Your Ref: OWPC21062
Our Ref: WA/89/18/L 12-10-2018
Please ask for:
Zac Denton

Listed building consent for a replacement 1.19m high privacy screen, affixed to the existing 0.48m high dwarf wall giving a total height of 1.81m to North and West sides of patio.

9 Walberton Park Walberton

Drawing / Elevation
of replacement
Privacy Screen
above existing
dwarf Wall

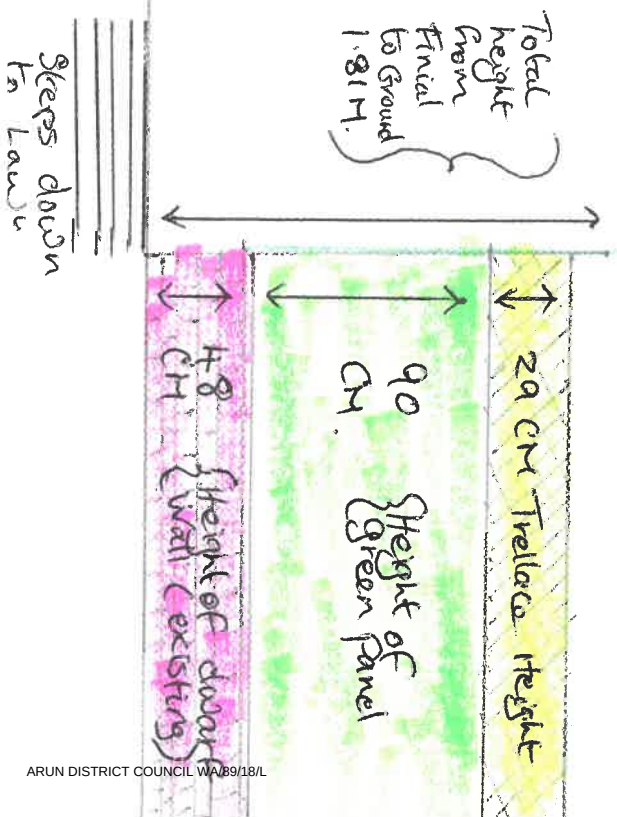
This obtrusive large metal fence does not fit in with the character of the Grade 11 listed property. The original screen was a hedge which had it's roots on the external sides of the low patio wall such that the wall did not show on the external elevations as shown on a submitted image, allegedly taken in 2010. There was no additional fence above or fixed on the top of the dwarf wall and therefore this is not a like for like replacement and is unsightly and not in keeping with the character of the listed property .
